### **Ecological comments**

Planning Application No: **3/2014/0438**

Proposals: **Development of 106 residential units, including affordable housing, new vehicular and pedestrian accesses, landscaping, public open space and ecological enhancement measures**

Location: **Land East of Chipping Lane**

Planting Schedule

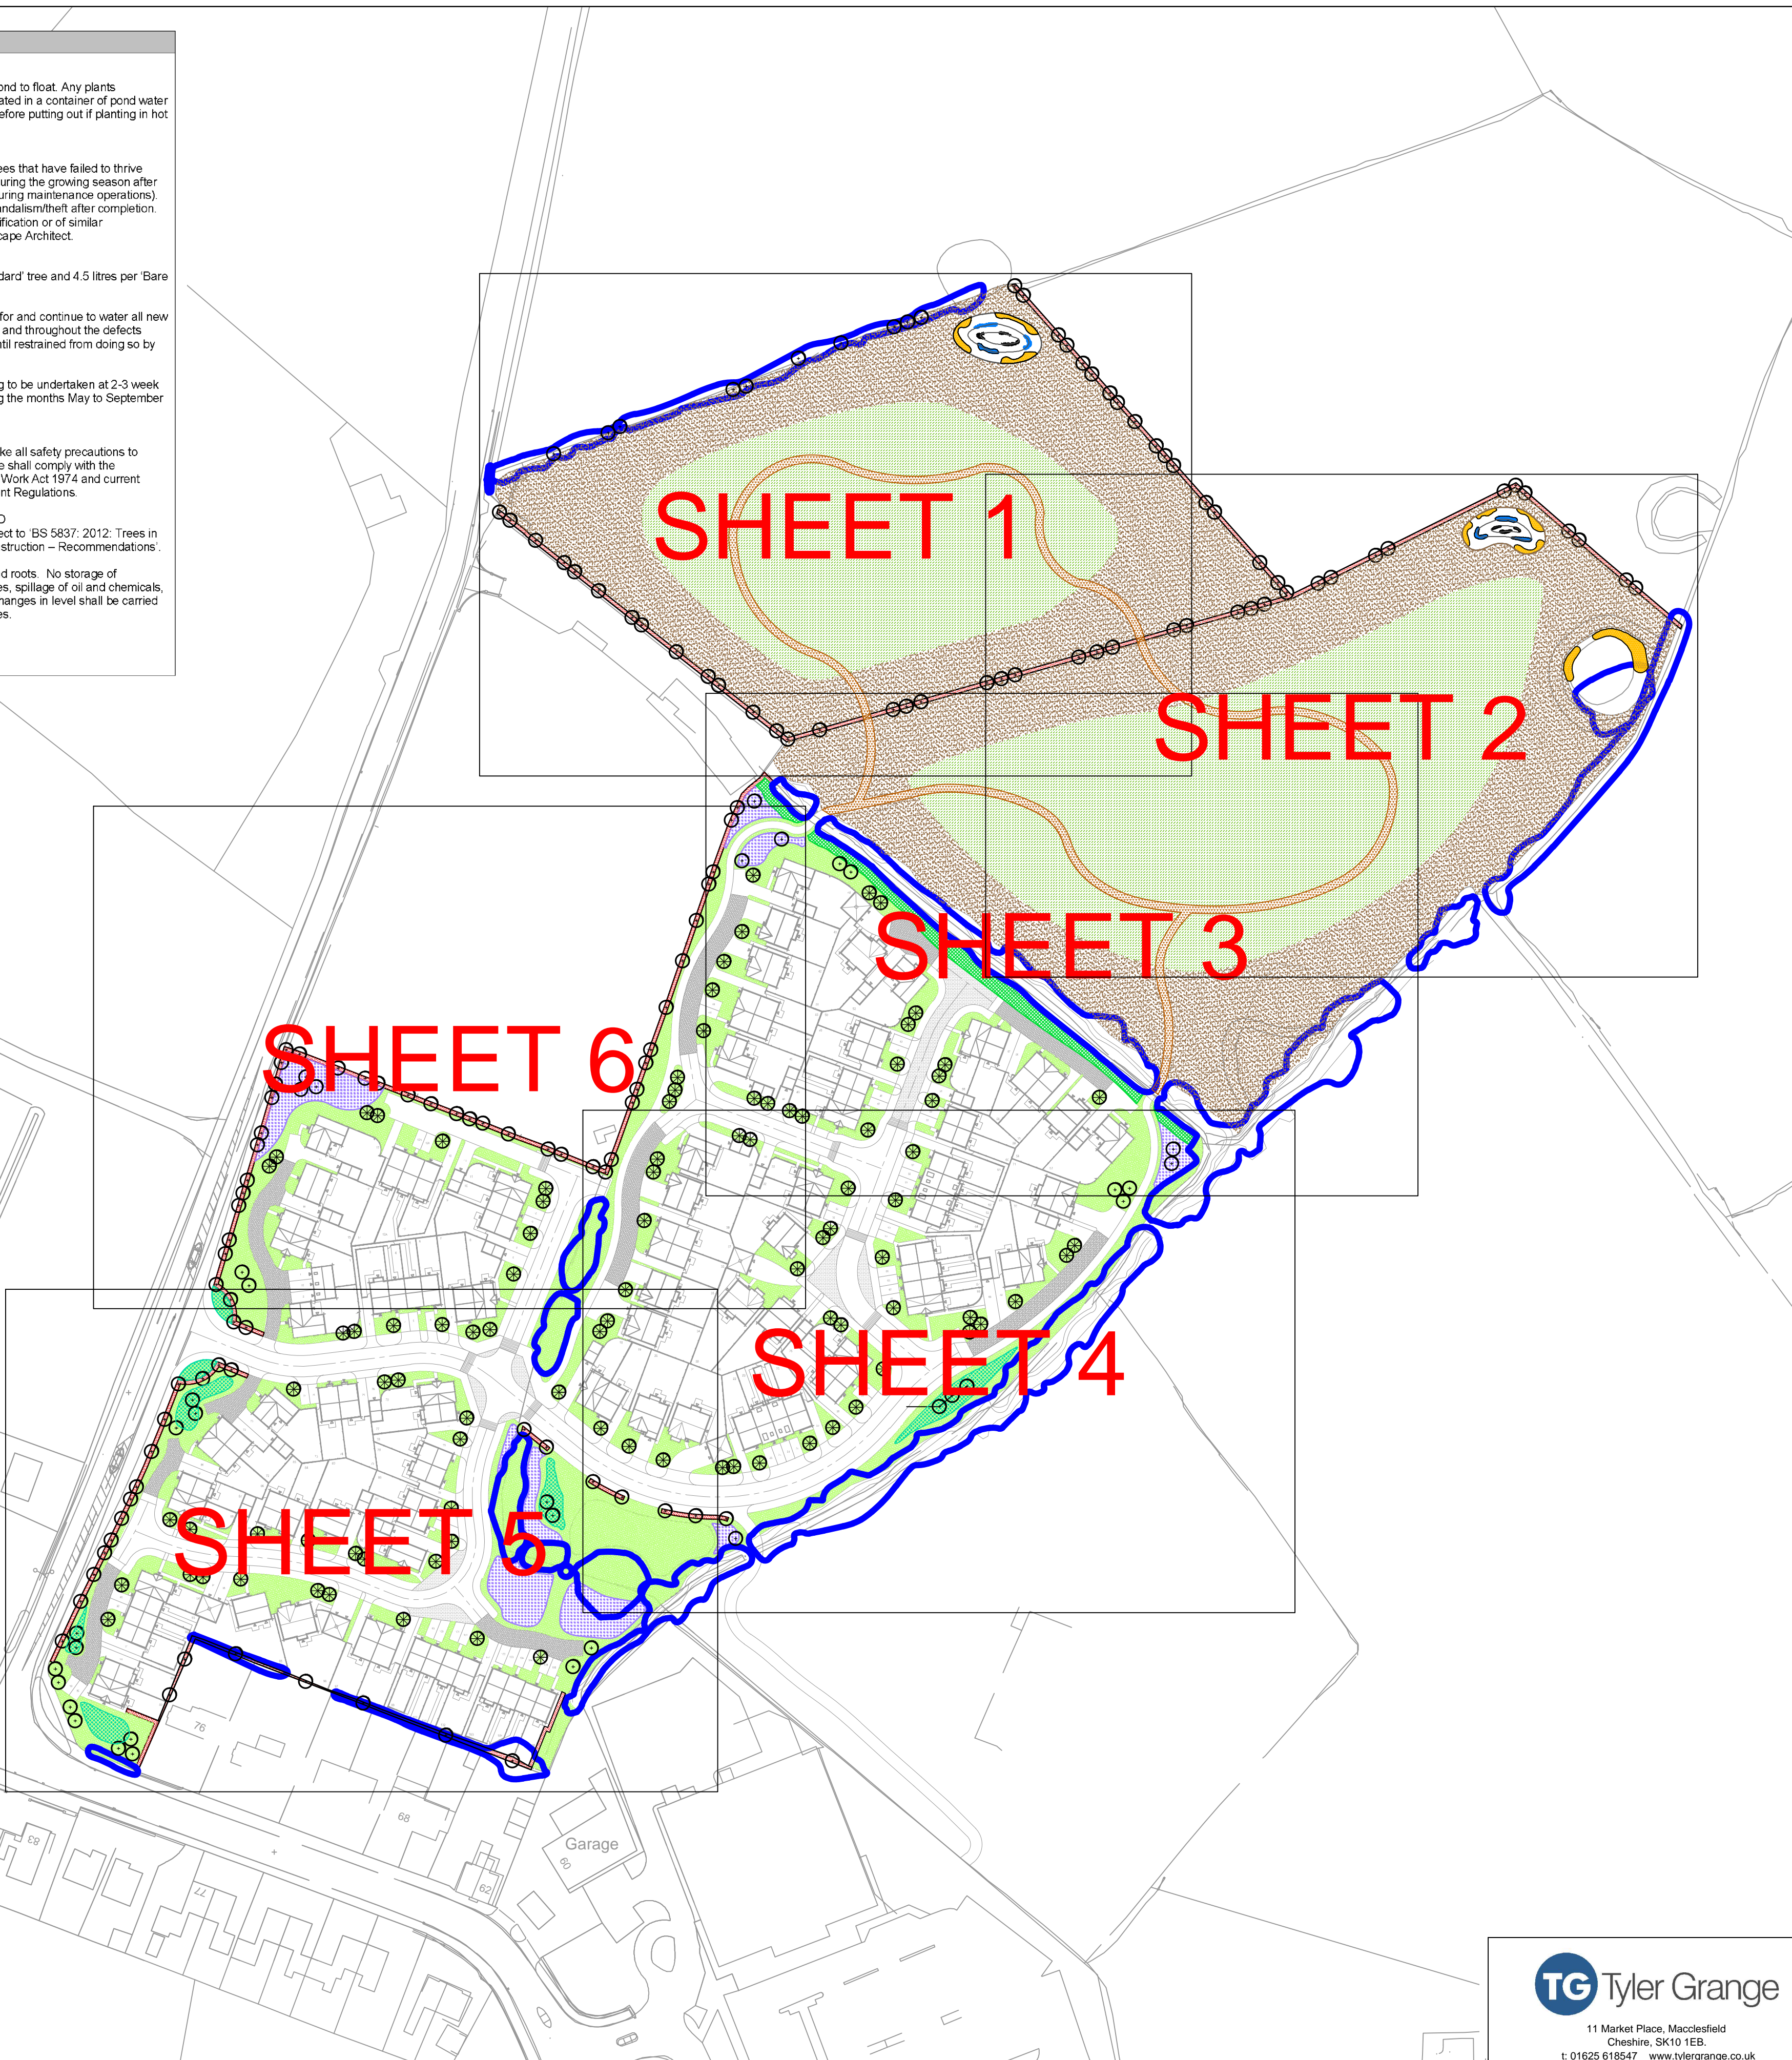
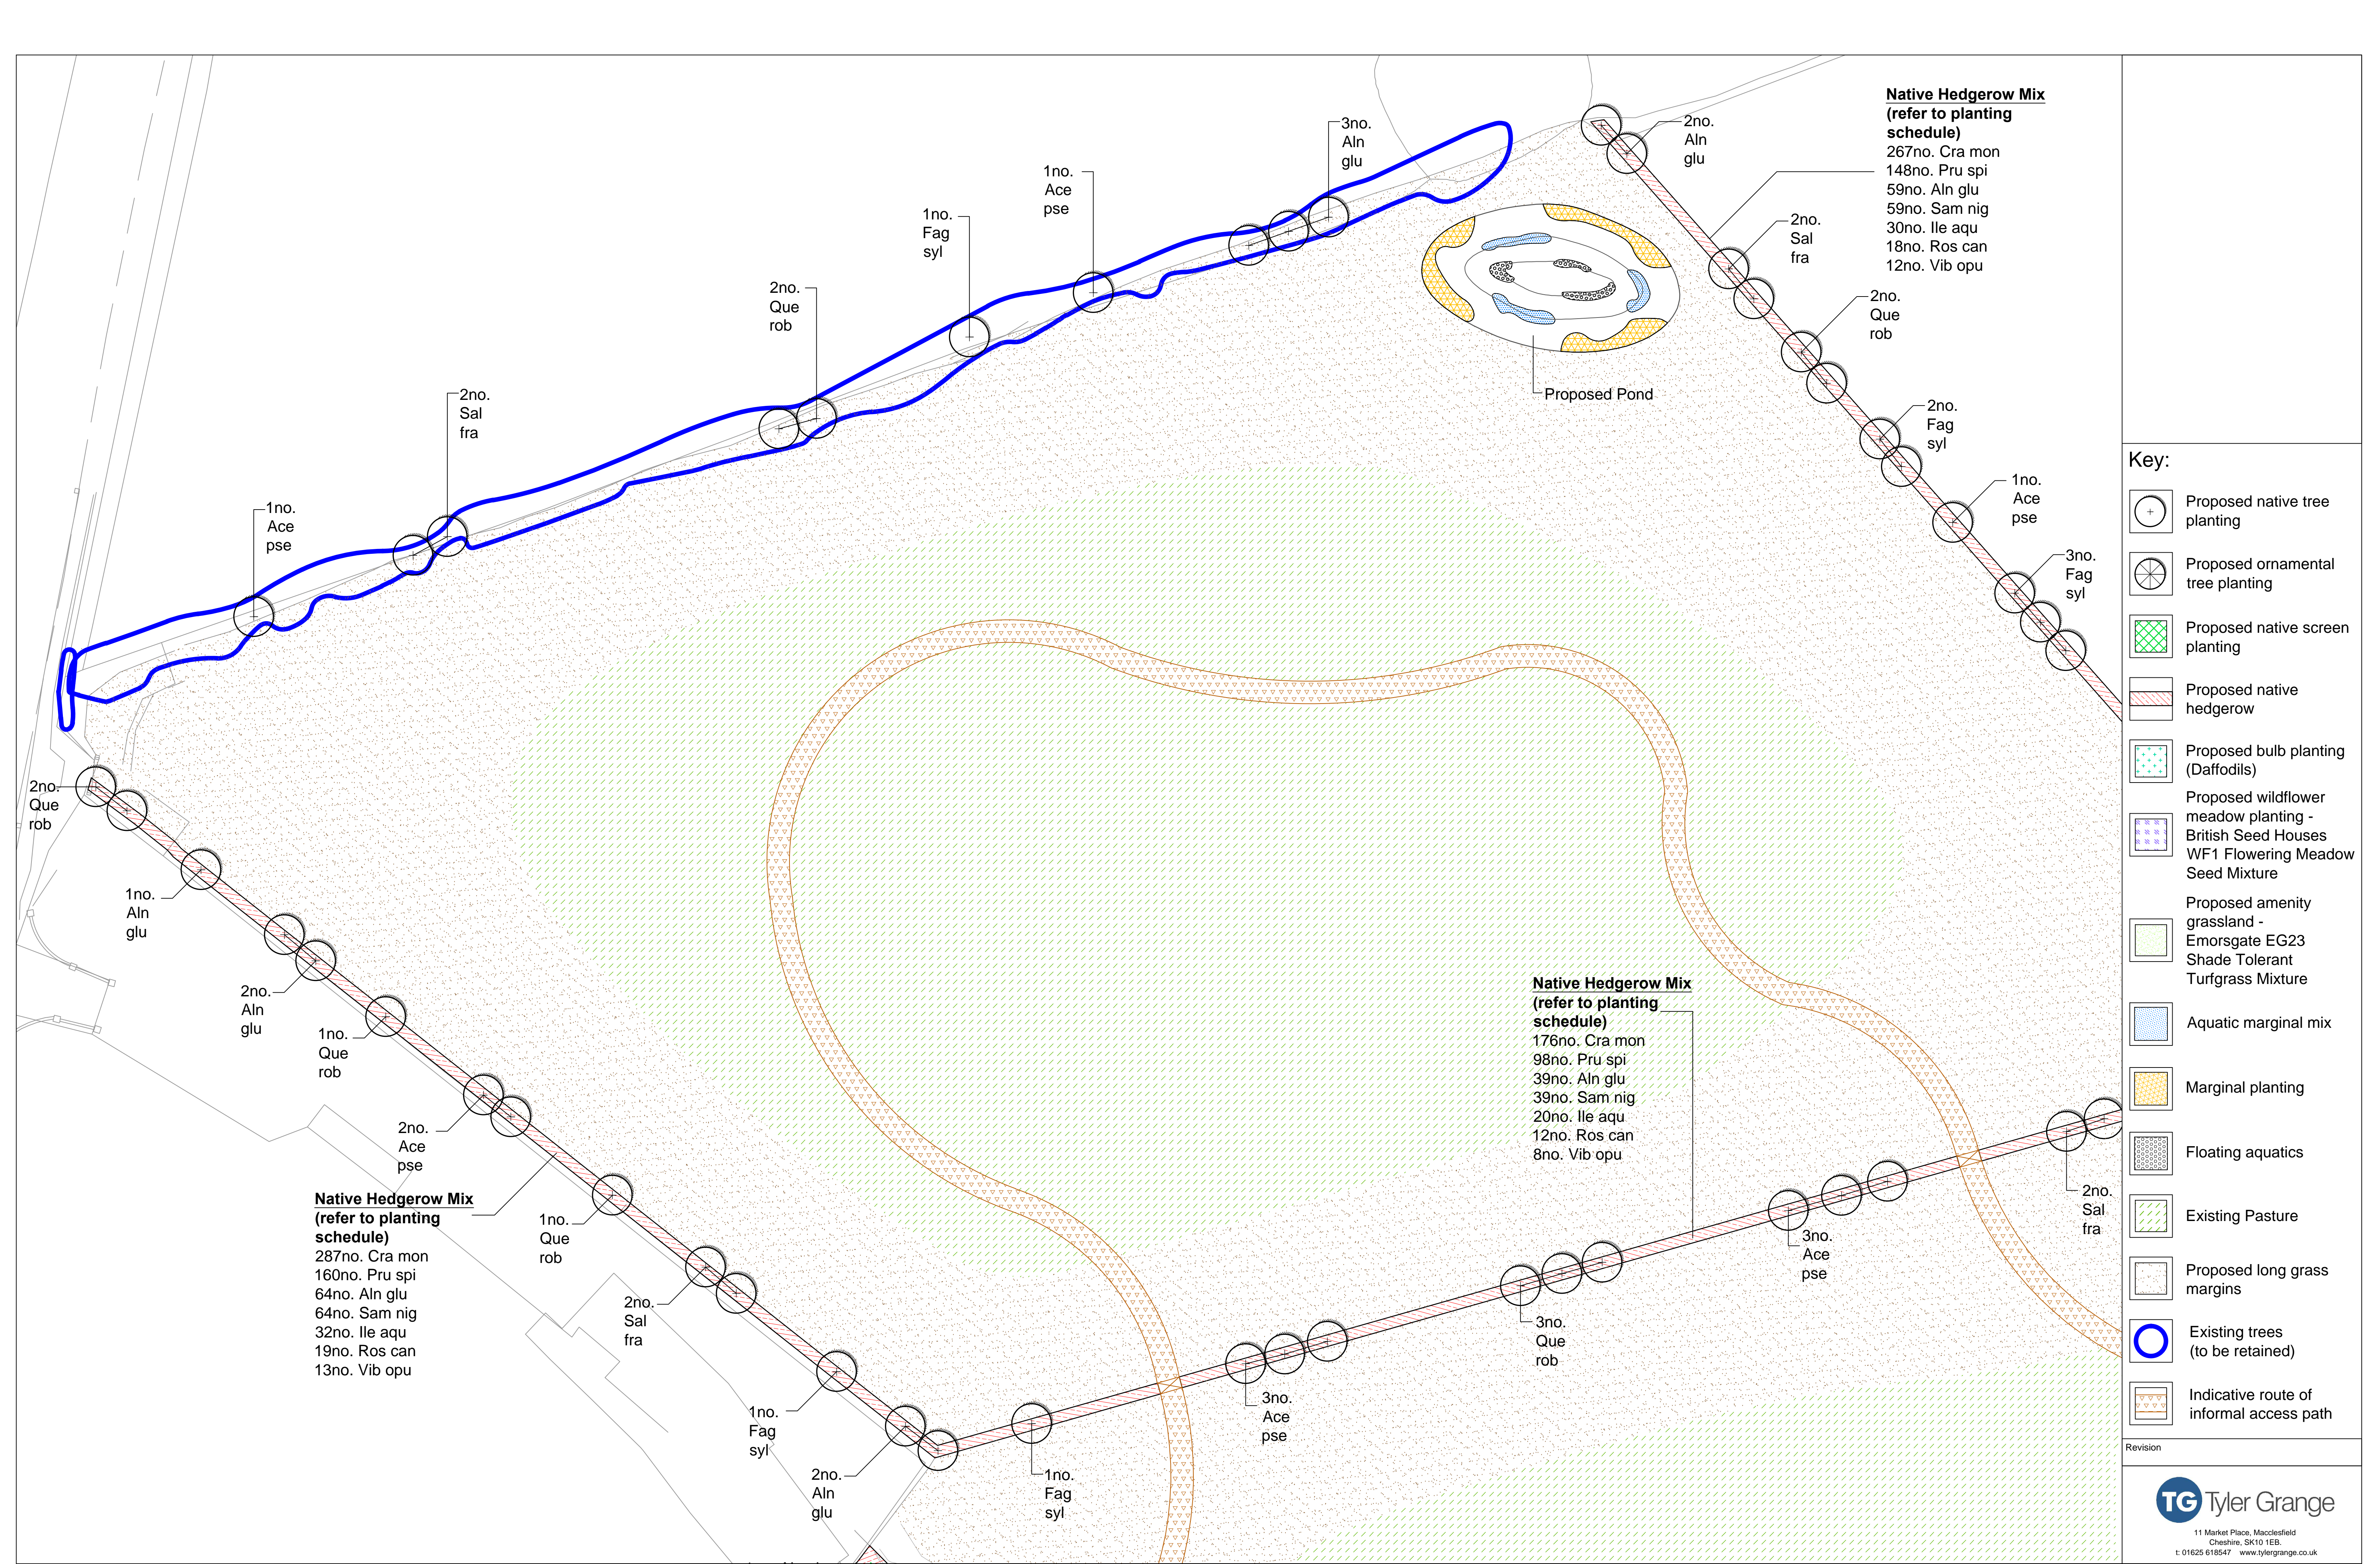
- The proposed "native tree planting" mix contains a number of species not native to the locality. The following species should be omitted: Sycamore, Cypress Oak, Common Beech, Dawyck Beech and Copper Beech. In addition to inclusion of Alder, Pedunculate Oak and Crack Willow I recommend that consideration is given to inclusion of Wild Cherry (*Prunus avium*), Rowan (*Sorbus aucuparia*), Hazel (*Corylus avellana*) and Silver Birch (*Betula pendula*).

- All species in the proposed native hedgerow mix are native and appropriate to the area, however I recommend that Elder is excluded due to its invasive nature in hedgerows.

- Planting of marginal vegetation in the existing pond is proposed. New planting should not be introduced to existing ponds.
- A number of species proposed in the marginal and floating planting mixes are inappropriate to the locality. Arrowhead (*Sagittaria sagittifolia*), Greater Pond-sedge (*Carex riparia*) and Greater Spearwort (*Ranunculus lingua*) should be omitted. Alternative appropriate species would be Lesser Spearwort (*Ranunculus flammula*) and Flowering Rush (*Butomus umbellatus*).

- In addition a number of species proposed for aquatic planting are inadvisable as their invasive nature would cause future management problems and would accelerate the succession of the pond. I recommend that Yellow Iris (*Iris pseudacorus*) and Lesser Pond-sedge (*Carex Riparia*) are omitted.

The British Seed Houses wildflower mix proposed (WF1) contains species inappropriate to the locality, however due to the proposed location of such planting (affectively as amenity beds within the residential development) in this case this is acceptable.
